KITTITAS COUNTY FIRE MARSHAL'S OFFICE

Pre-Application Conference Notes CU-22-00001

Project Name: Apostolic Faith United

Project Location: 141 Rein Rd 951598

SITE PLAN
WALTER DAVENPORT
(17-19-08055-0002)
SCALE: 1" = 120'

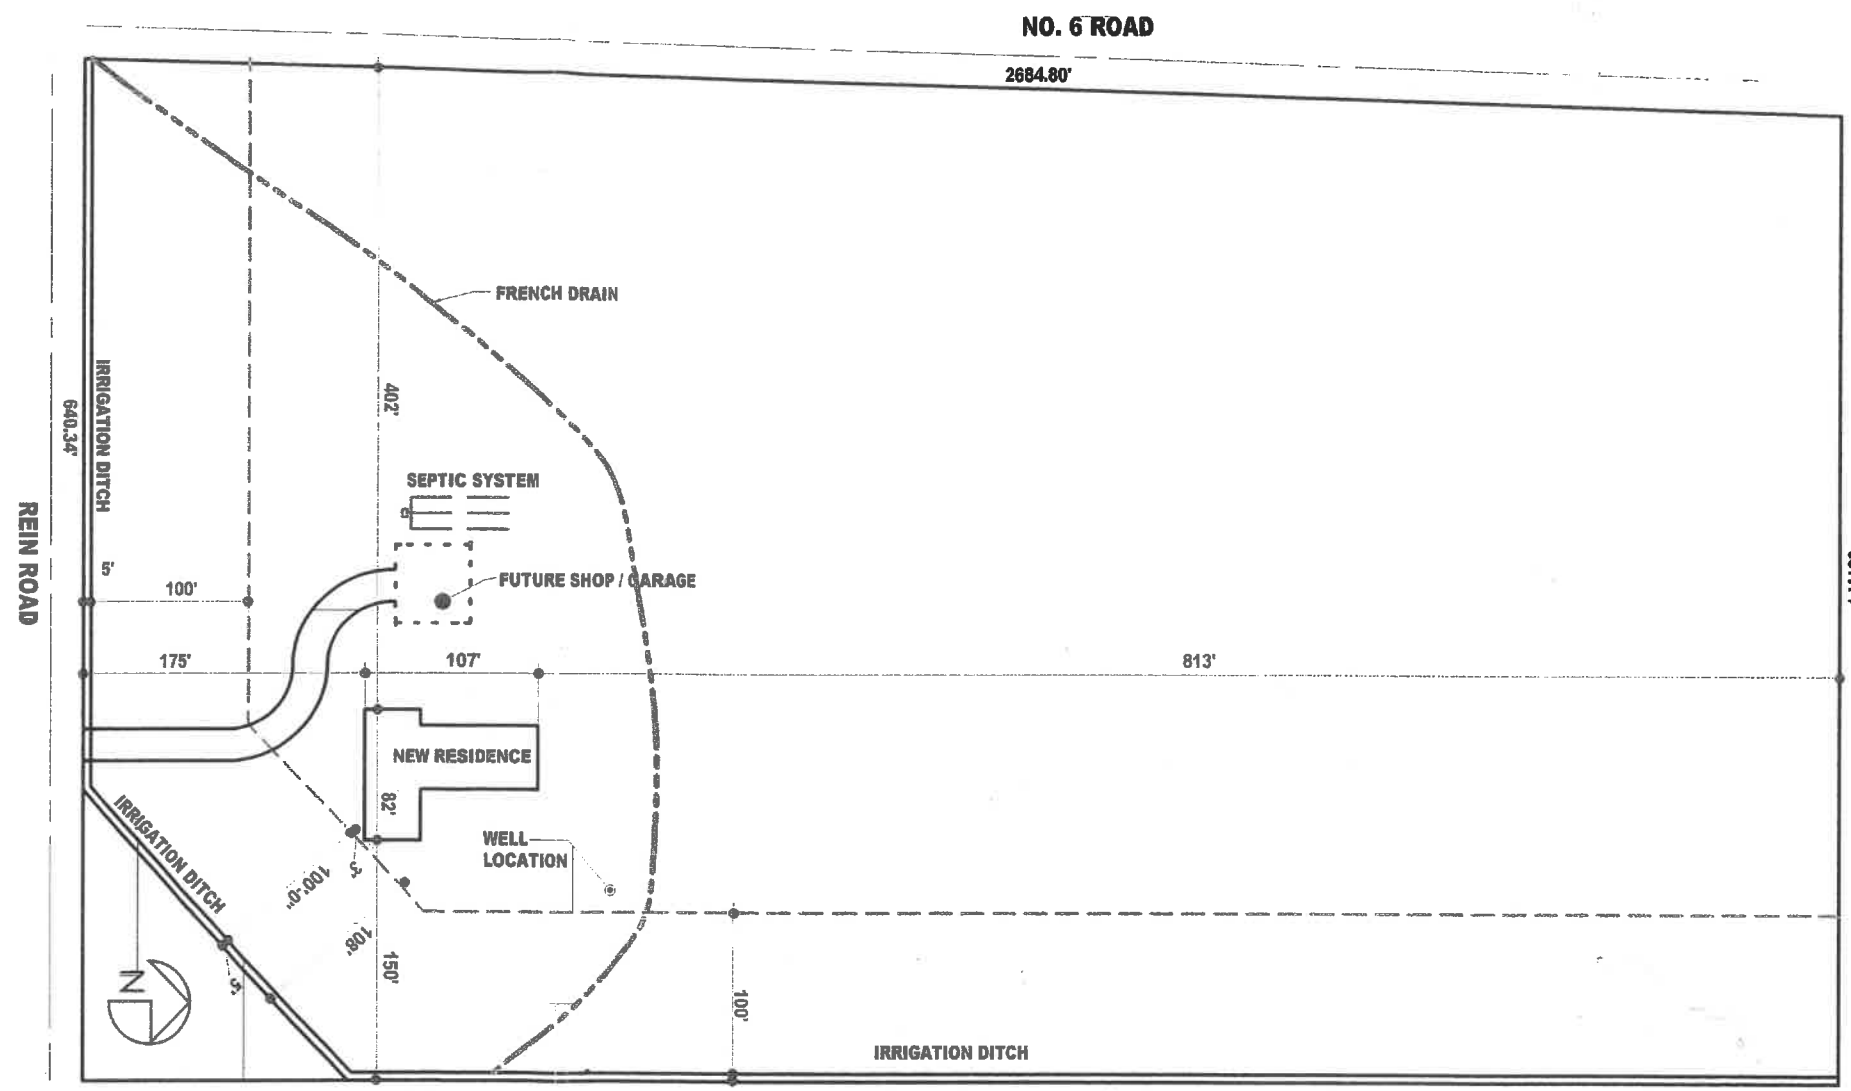
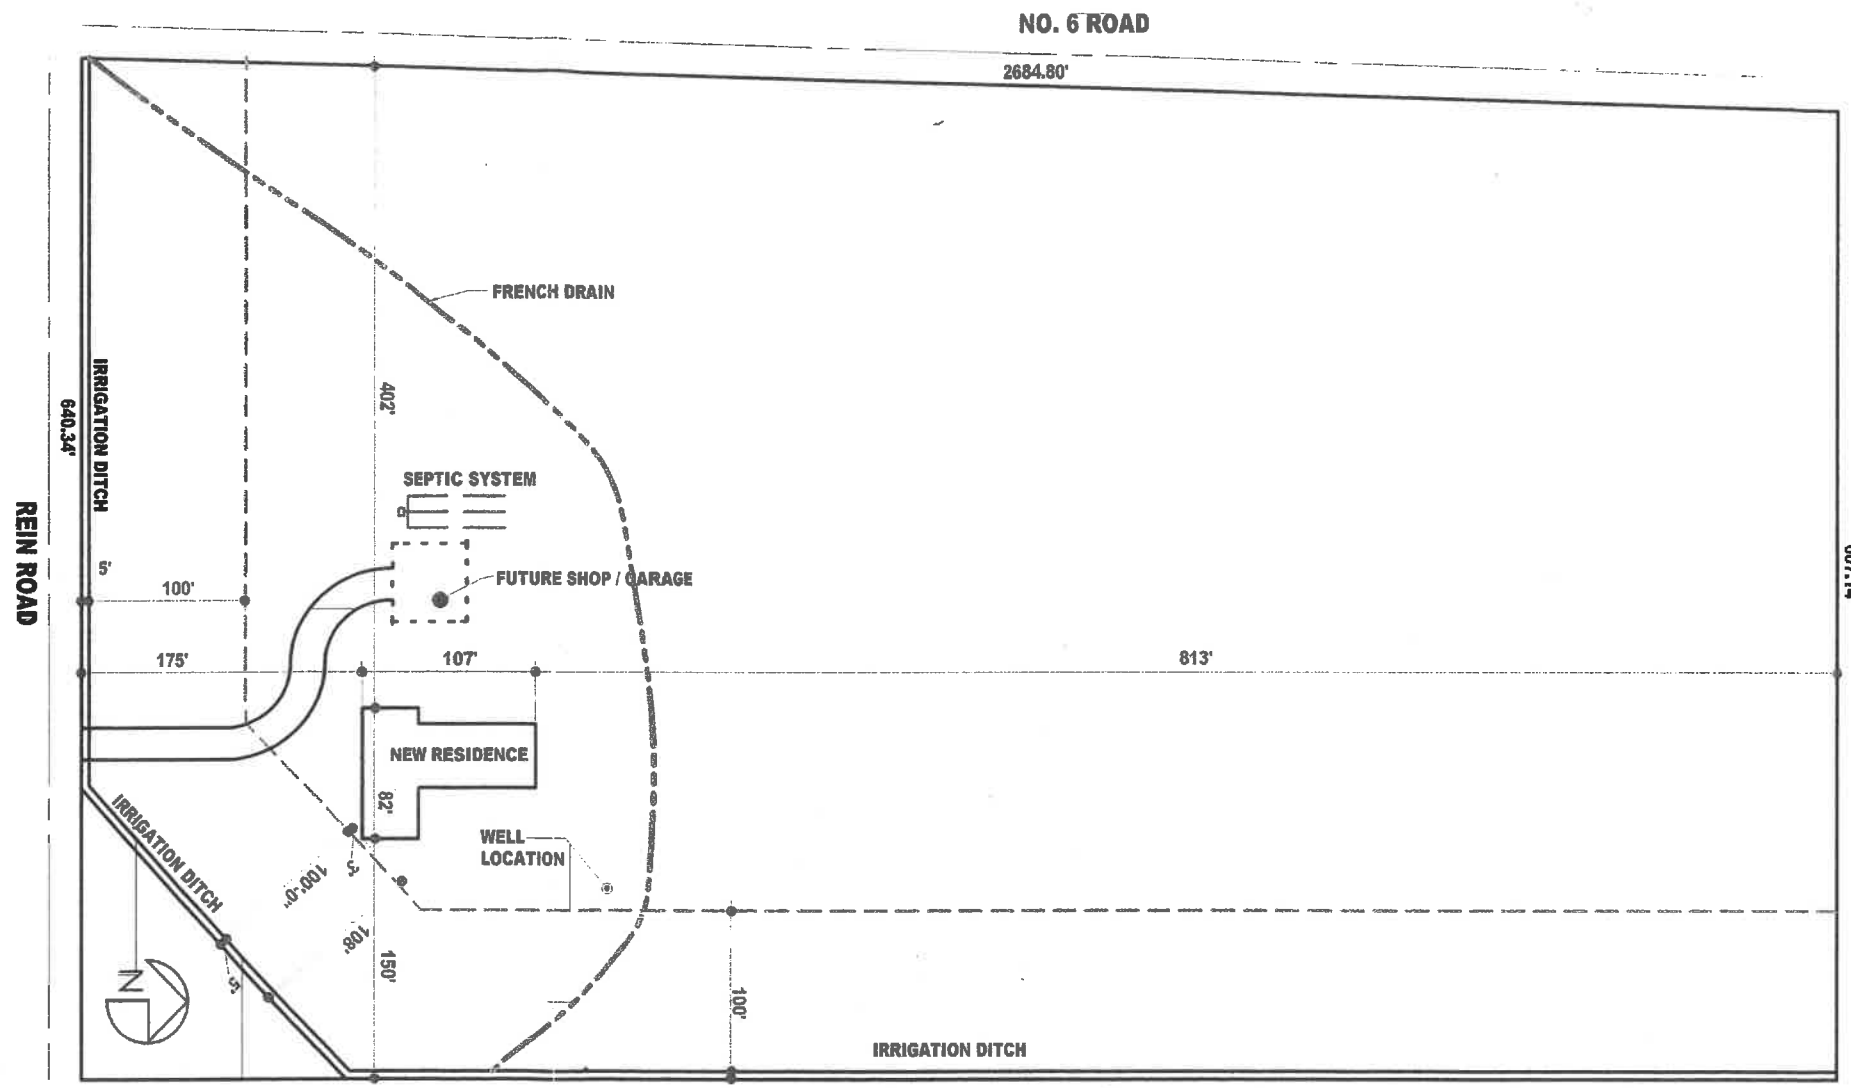
X Fire Apparatus Access road to be compliant with 2018 International Fire Code Appendix D and County Road Standards. The road used to access the storage units and to drive around the building is considered a fire lane.

The fire lanes must be 20 feet wide.

X Key box required

International Fire Code 506. Contact Knox Company and choose a product that will facilitate rapid access to a restricted area for fire and life-saving purposes. Gates require immediate access – can be in the form of a Knox padlock or key switch that will activate the gate opener.
